From: Giovanni Cirillo <giovanni@planninglab.com.au>
Sent: Friday, 5 February 2016 2:11 PM
To: Fiona Gibson; Anthony Witherdin
Cc: Giovanni Cirillo
Subject: The Esplanade, Ettalong
Attachments: DA Landscape Plan 050216.pdf; J15304 47-50 The Esplanade Ettalong Beach Town Centre _ DA _ C _ fullset _ 160204 2 low reso.pdf

The architect has revised the drawings arising from our last email exchange and I attach them to this email.

In summary, the changes address Council's submission directly, and the Department's identified issues, as follows by:

Job no	Drawing no	Rev
J15304	DA 101	C
Drawn by PY	Checked by ZC	Date NOV 2015

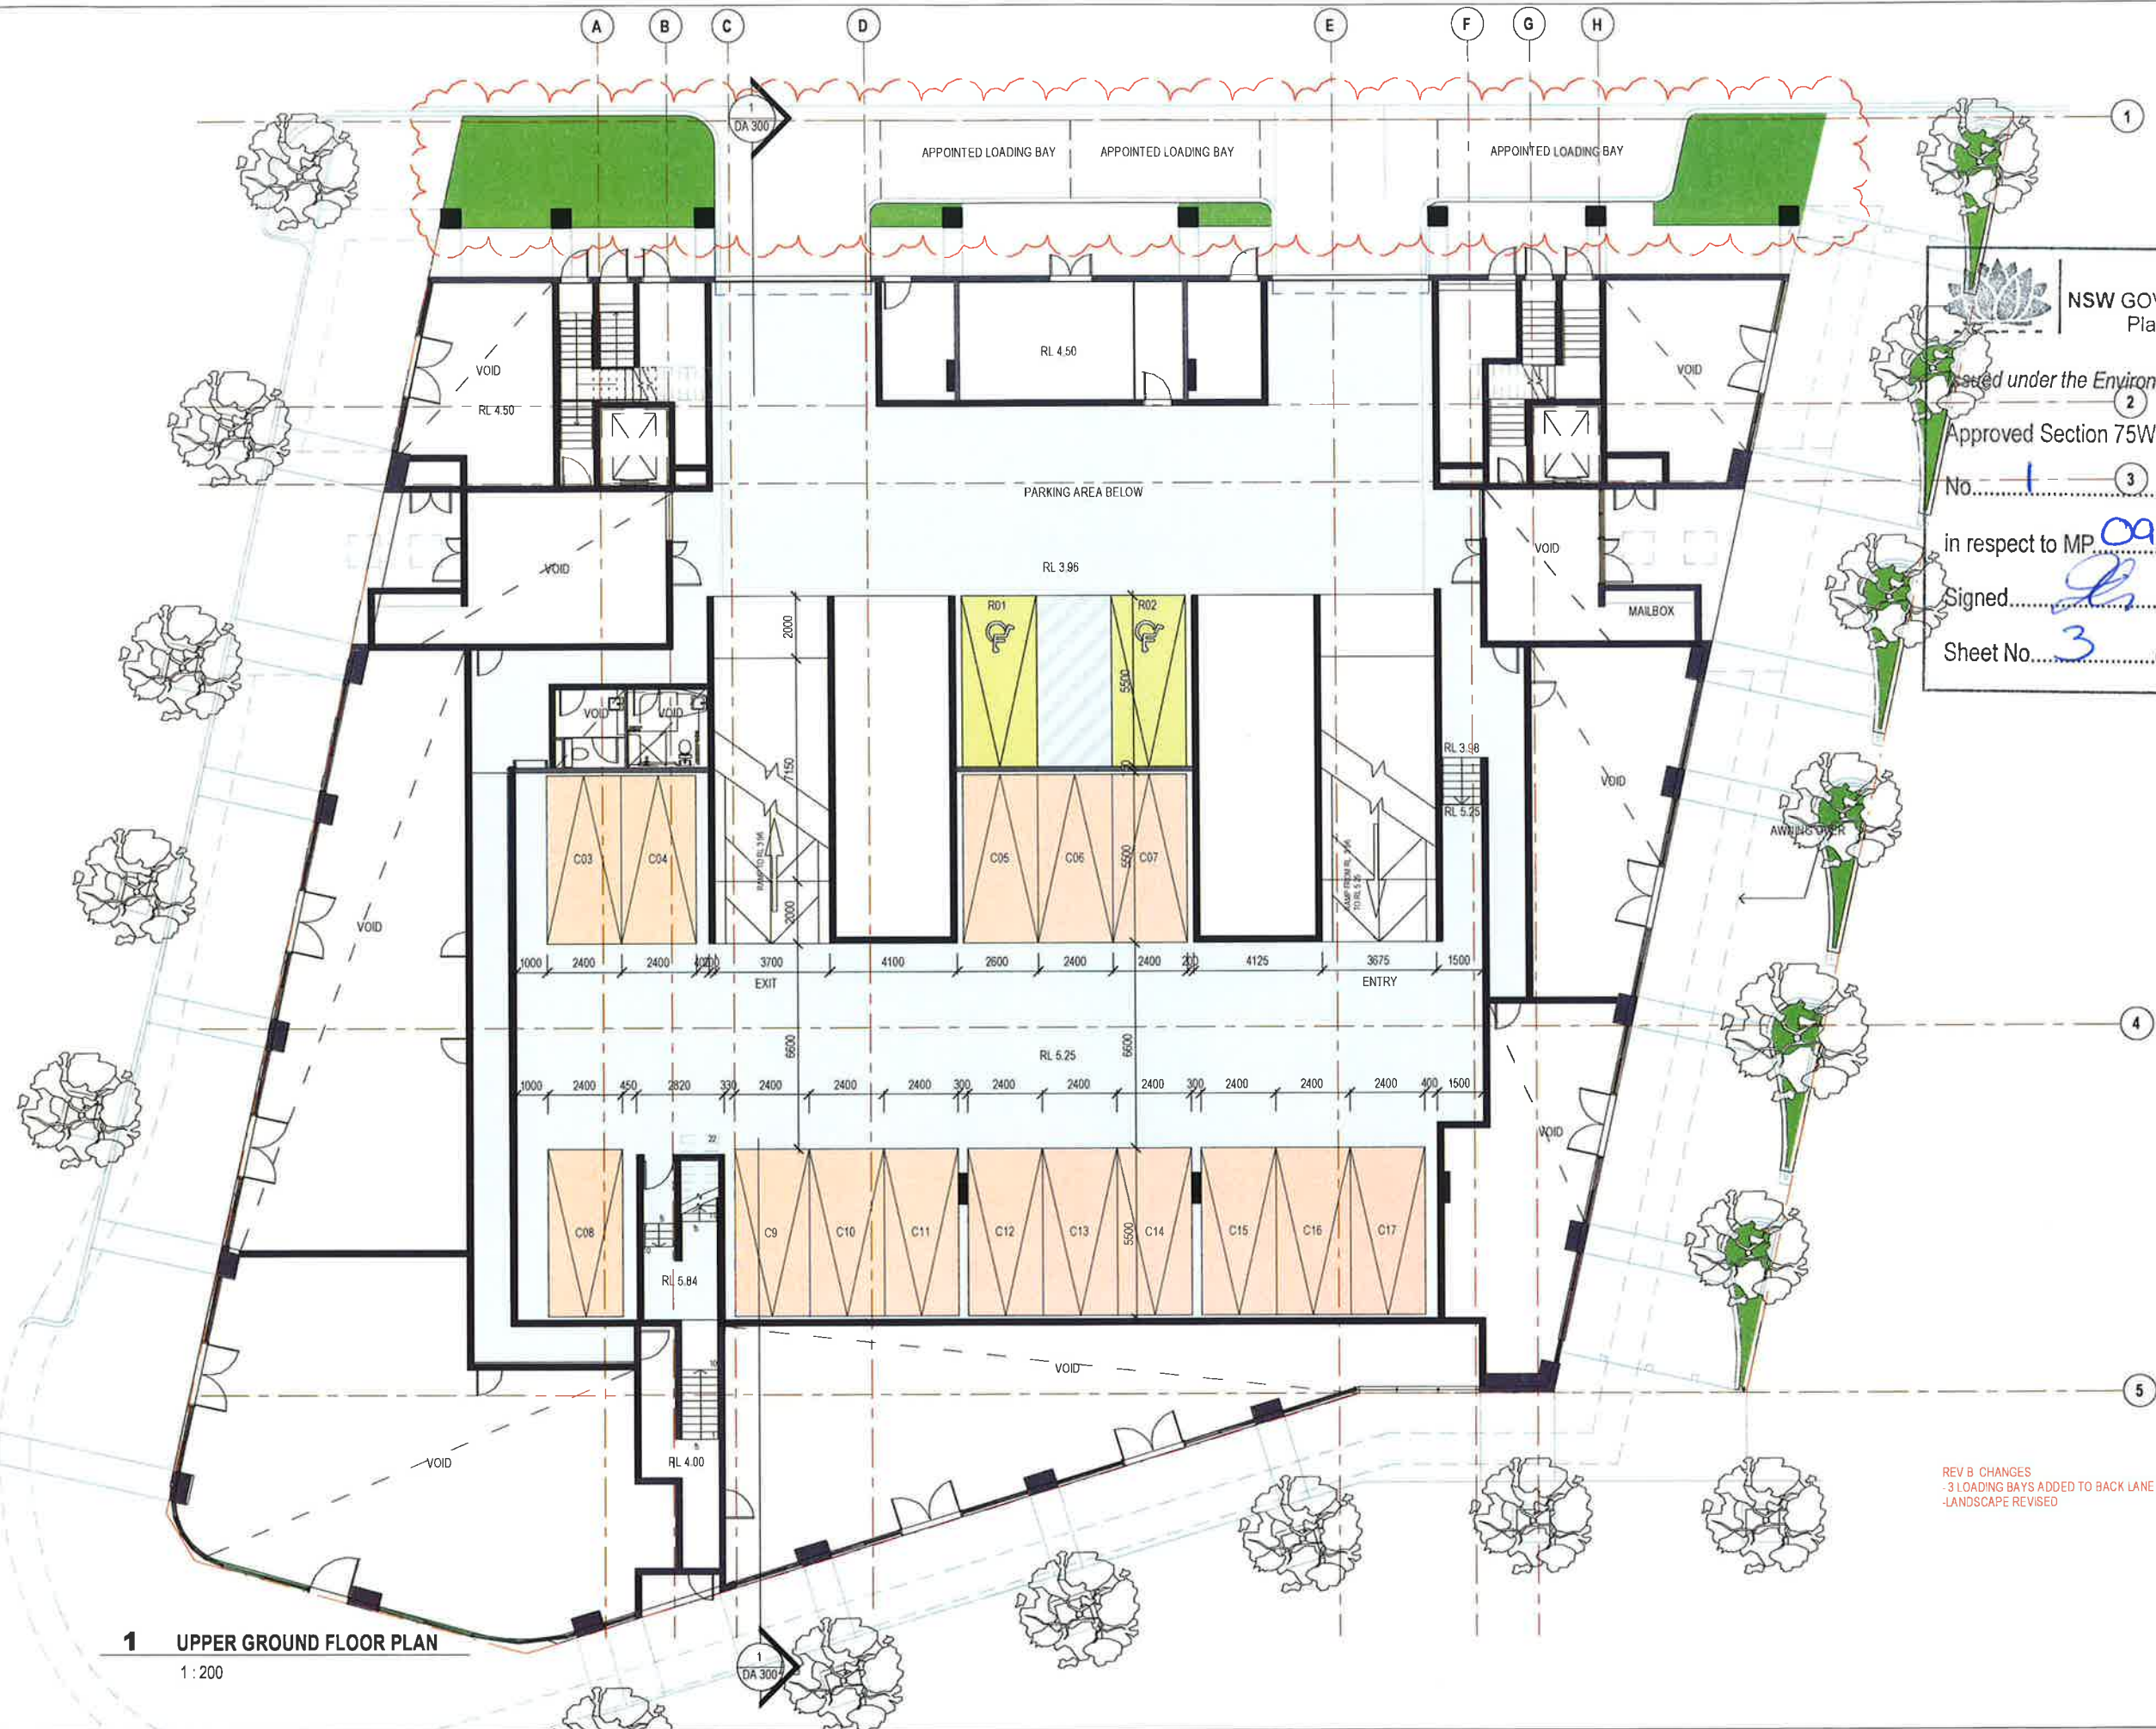
7. Providing landscaping on the ground level at the rear of the site adjacent to the loading areas, so as to fully accommodate Council's recommendation in this regard.

47-50 THE ESPLANADE ETTALONG BEACH
Drawing Title
**LEVEL 03
FLOOR PLAN**

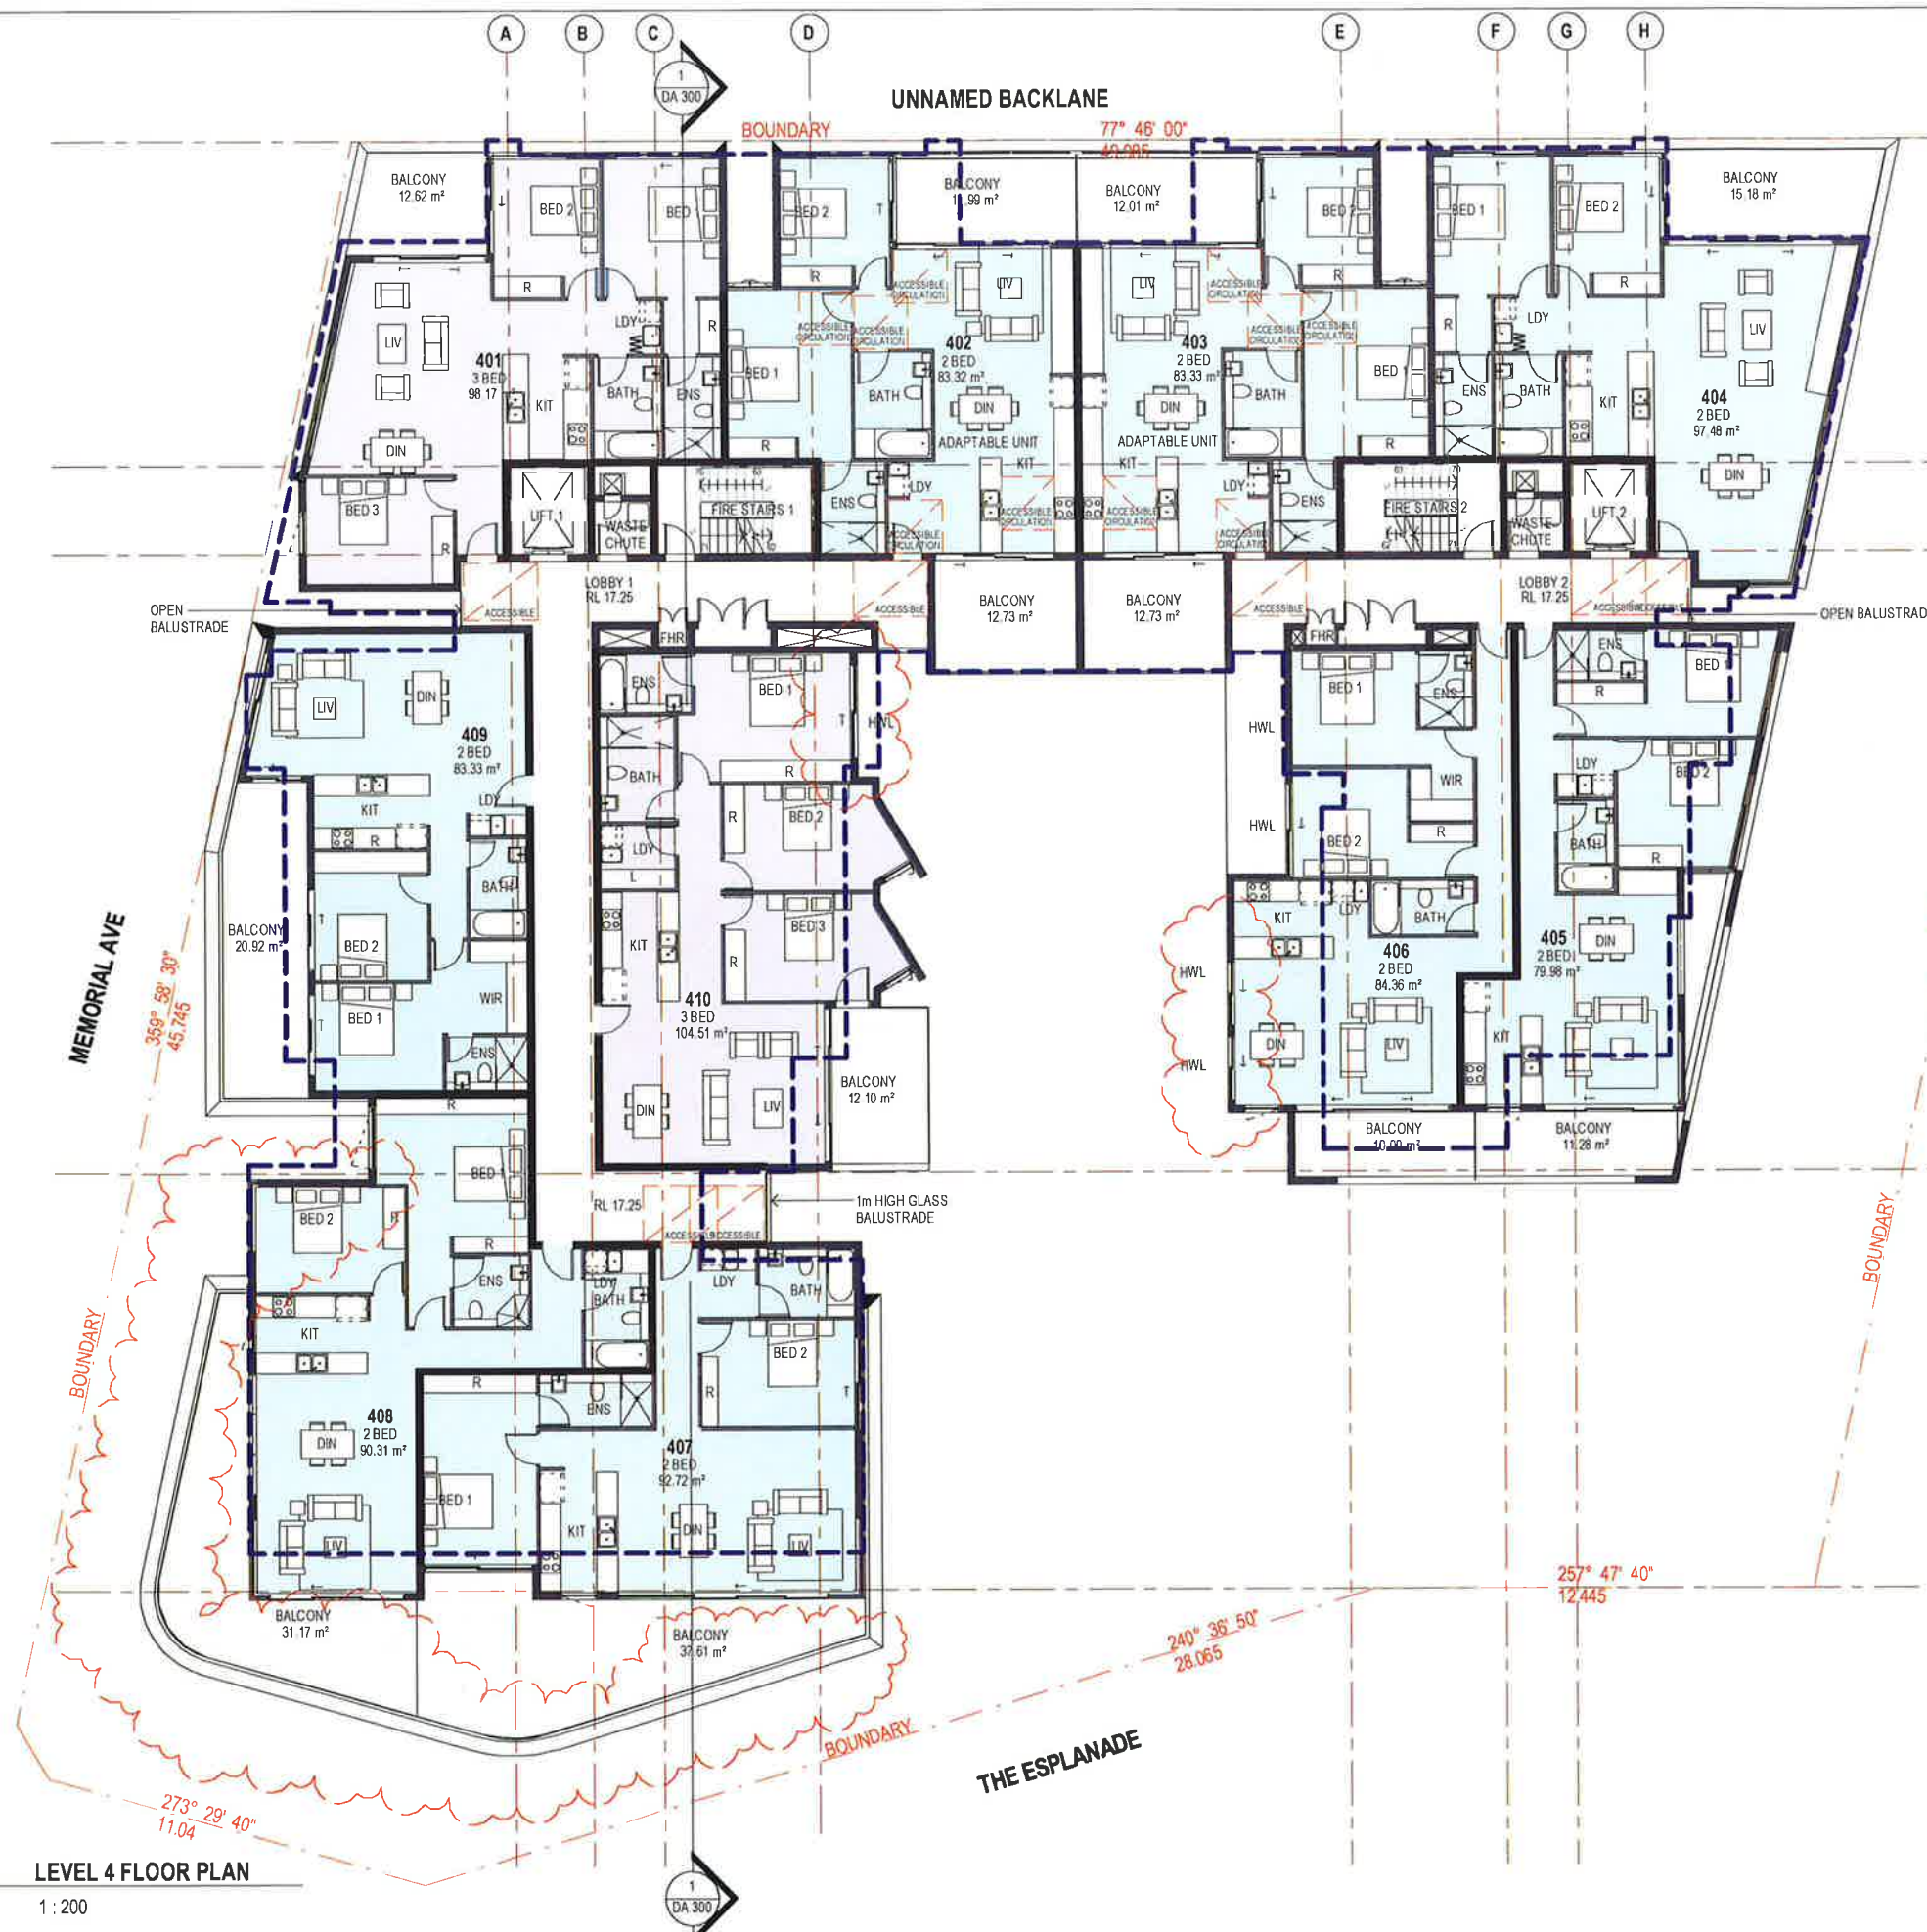
1. Reorienting and re-planning units 113, 115, 213 and 215 so that they are rotated 90 degrees into dual aspect apartments, each having cross ventilation, external outlook and beach views;

DA SUBMISSION		
Job no	Drawing no	Rev
J15304	DA 106	C
Drawn by	Checked by	Date
PY	ZC	NOV 2015

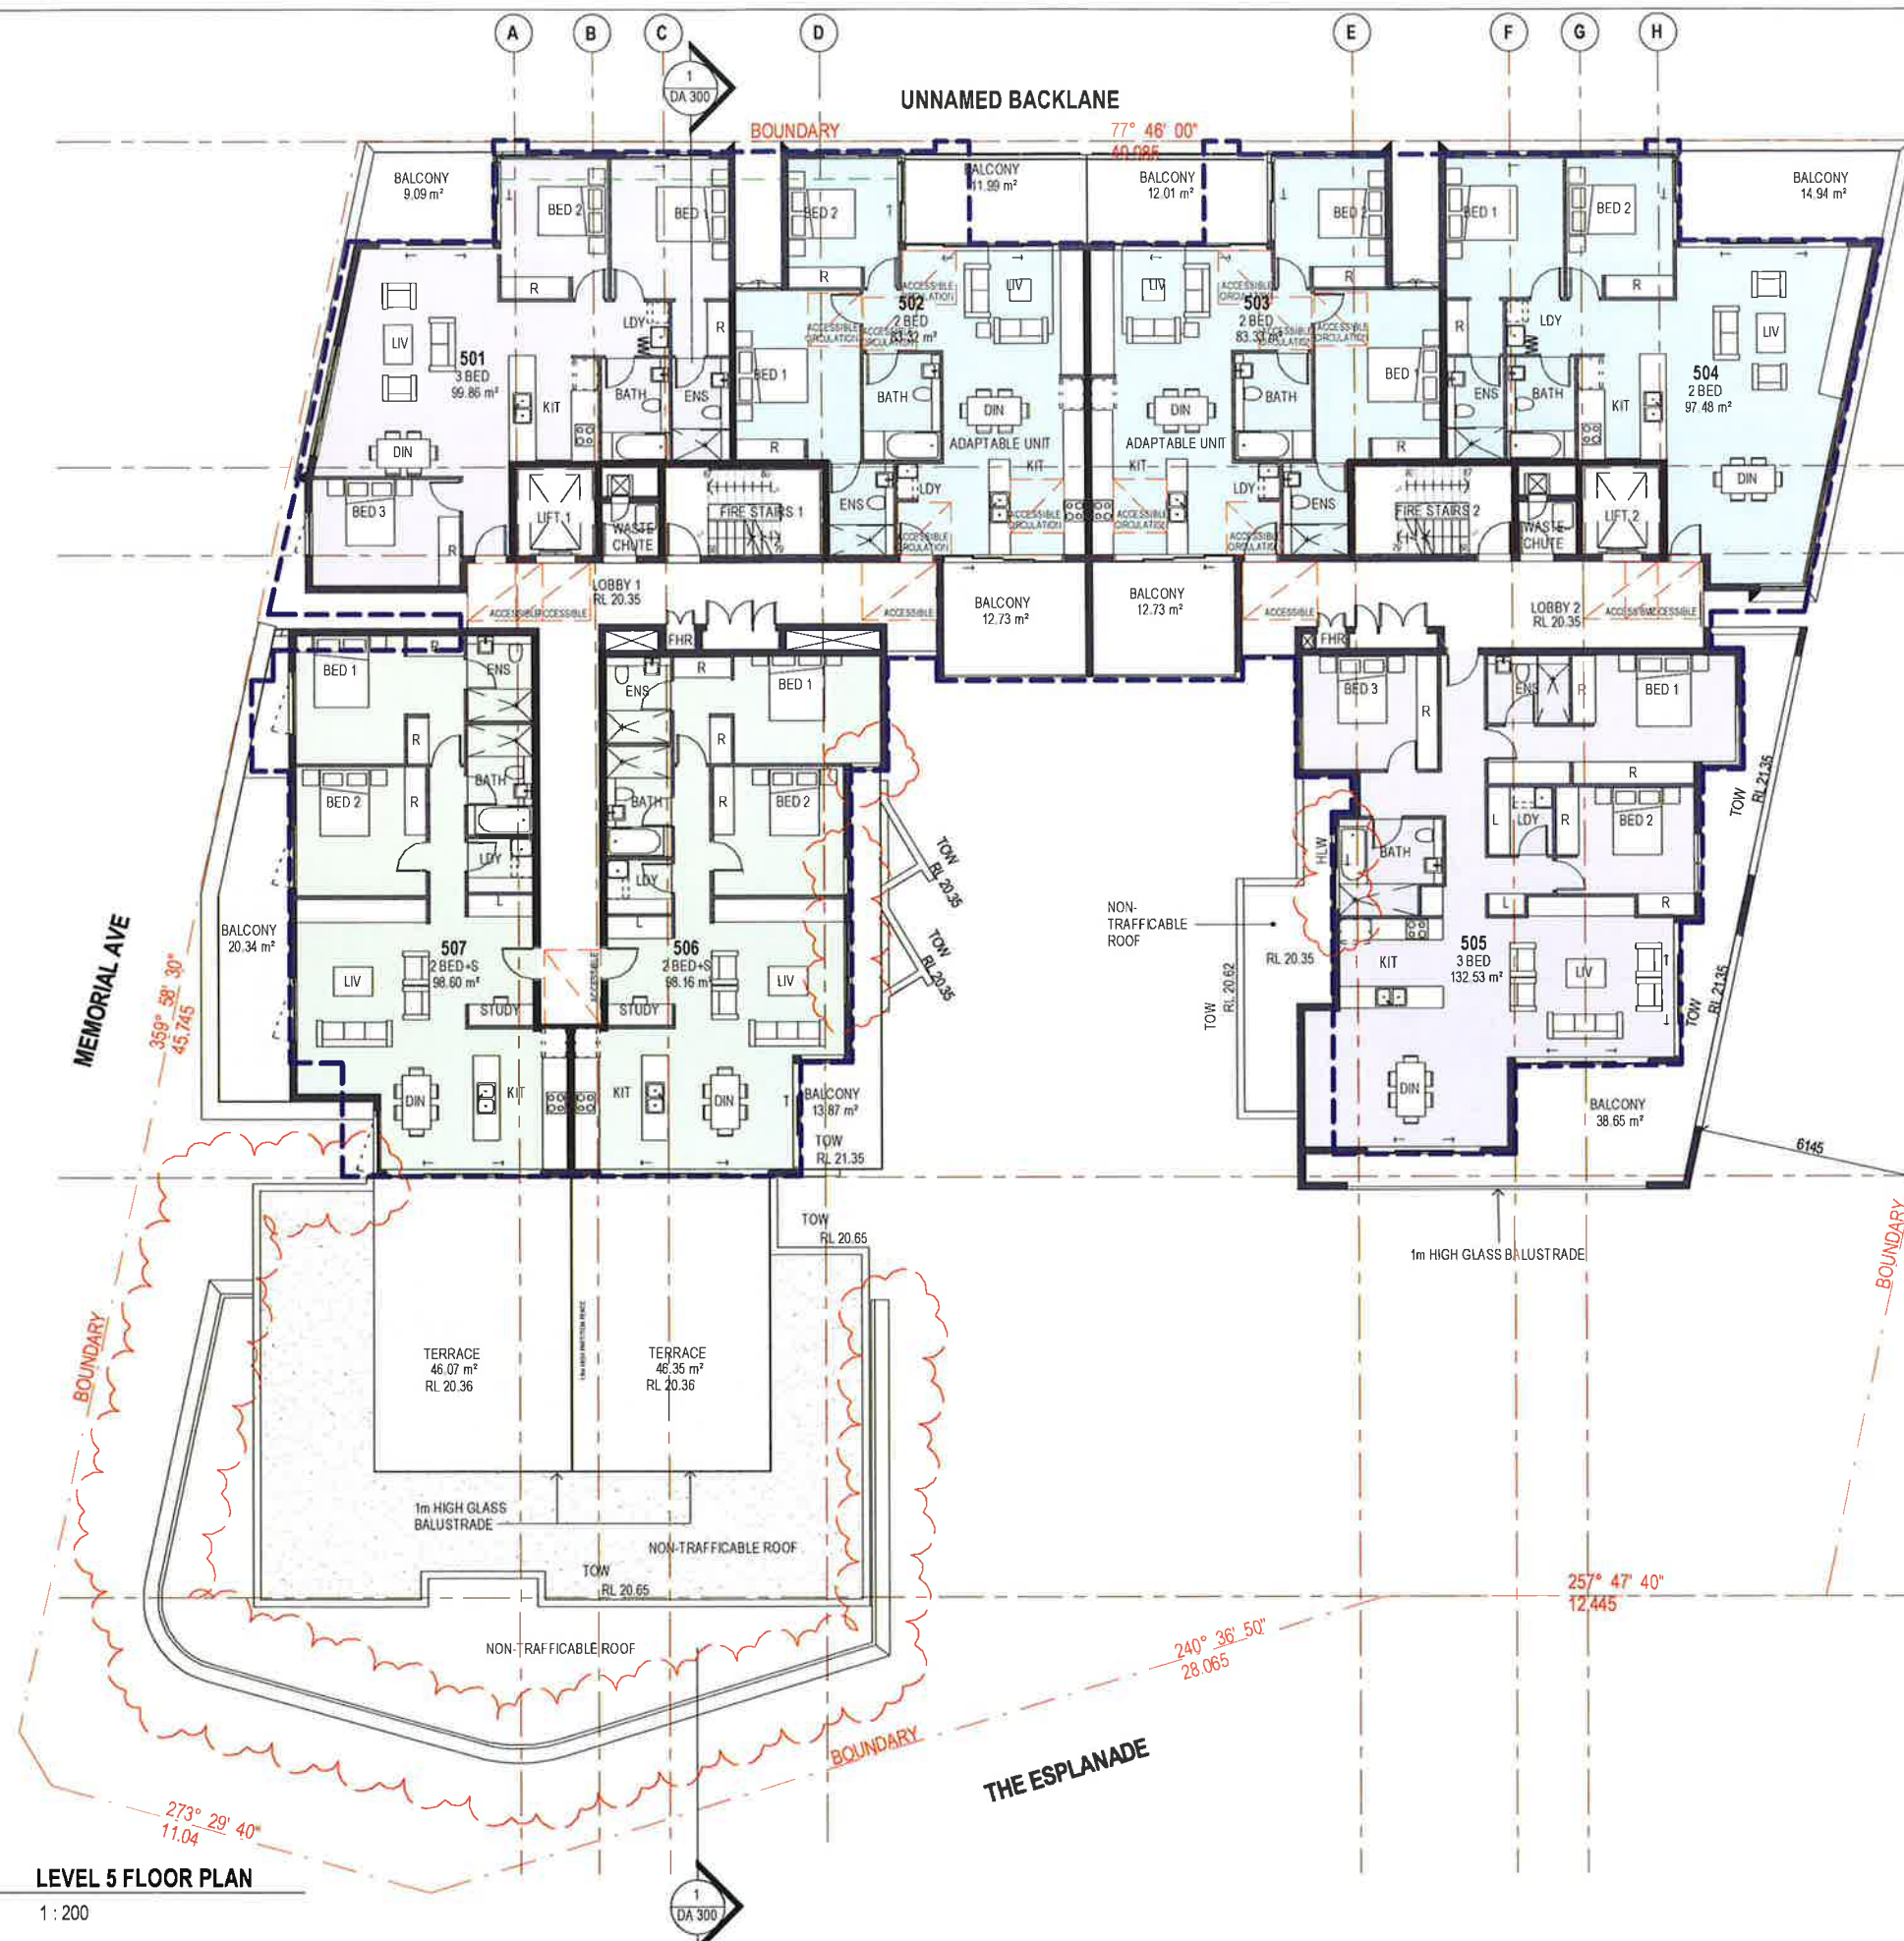
3. Increasing the setbacks from the boundary and reducing the size of the balconies on levels 4 and 5,
4. Tapering the edge profile and changing the colour and prominence of the balconies on levels 4 and 5 to preserve the predominant 3 storey scale of the development when viewed from the street;
